Application No: M/20/22/HH
Site Address: 48 Lane End Road Middleton-on-sea PO22 6LT
Description of works: The construction of an additional storey, rear single storey extension and detached garden building.

Thank you for your internet representation made on 3rd April 2022 which has been recorded as an objection with the comments as follows:

client	project	drawing	date	drawn	drawing no	revision
Jane Cutts	Extension at: 48 Lane End Road Middleton-On-Sea, PO22 6LT	Proposed elevations	Oct 21	pd	0358 / 102	D
			scale 1:100 @ A3	CAD file name:

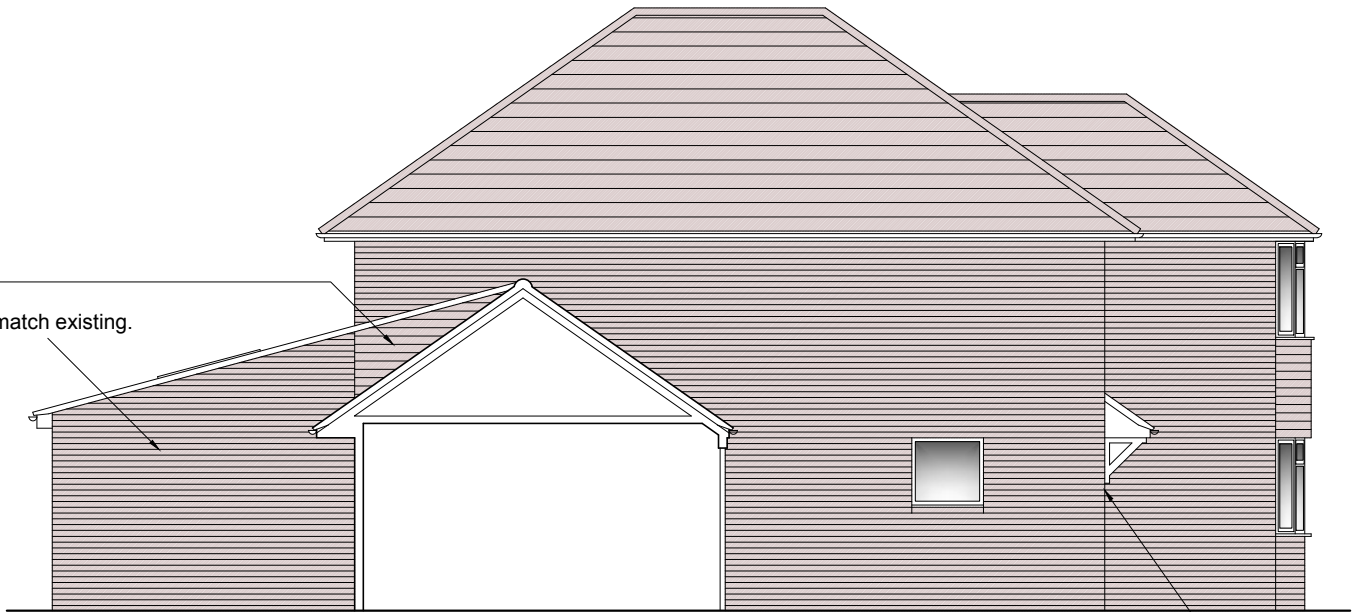
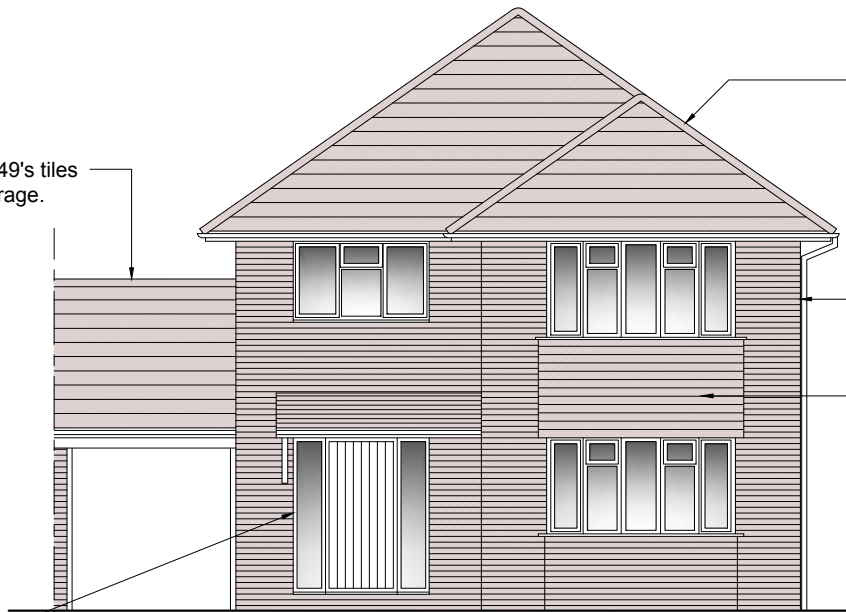
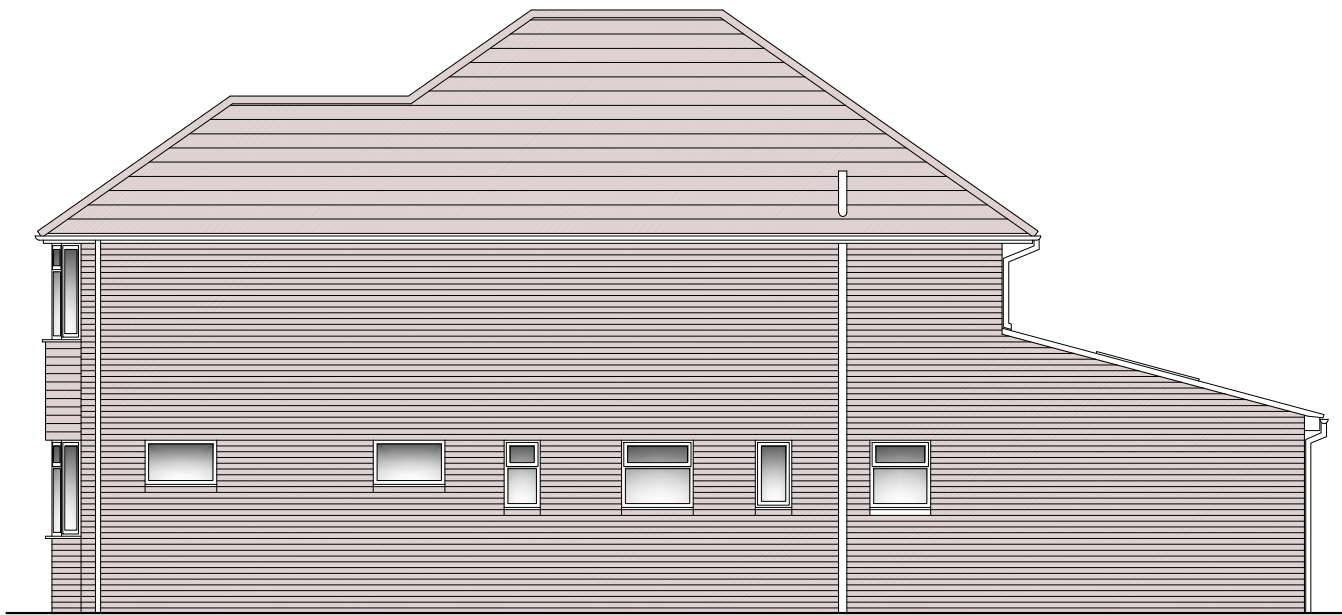
This proposed development would be totally different in appearance from any other property in Lane End Road.

Lane End Road is made up of mainly detached and semi-detached bungalows and No 48 is within a continuous row of 14 bungalows with 13 bungalows on the opposite side. Two of these properties have loft conversions but no properties in the road have added an additional storey changing the height and appearance of the buildings.

The property is not detached. It is attached to our property by the garages which is not evident from the outline plan.

As the immediate neighbour we would lose privacy and would be overshadowed, both to the side and rear of our property, due to the additional height of what would be a large four bedroomed house.

client	project	drawing	date	drawn	drawing no	revision
Jane Cutts	Extension at: 48 Lane End Road Middleton-On-Sea, PO22 6LT	Proposed Garden Room	Oct 21	pd	0358 / 103	B
			scale 1:100, 1:50 @ A3	CAD file name:

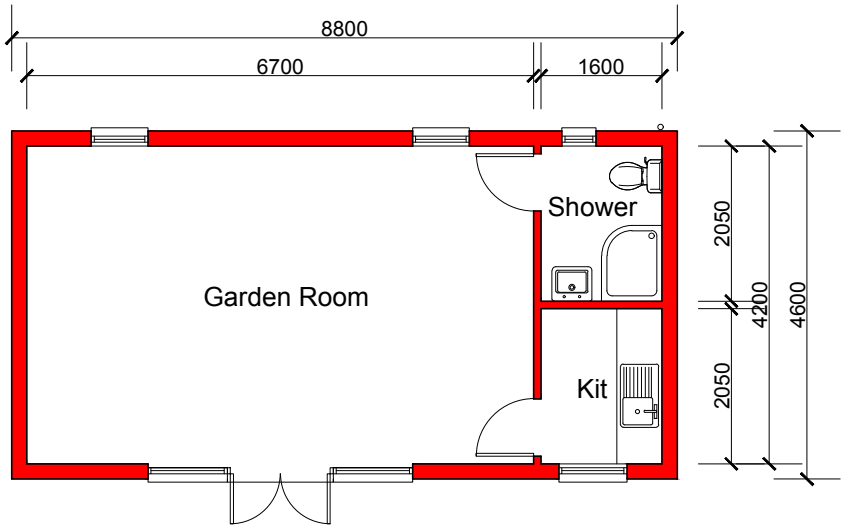
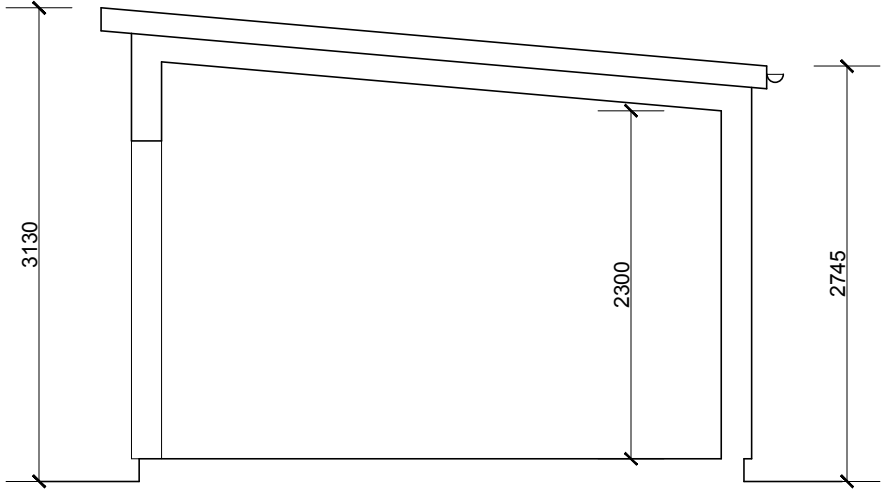
On the plans the proposed large garden room appears to be located very near or over the river at the rear of our properties. As riparian owners we are concerned about the possible impact of this and would ask that this is looked into please.
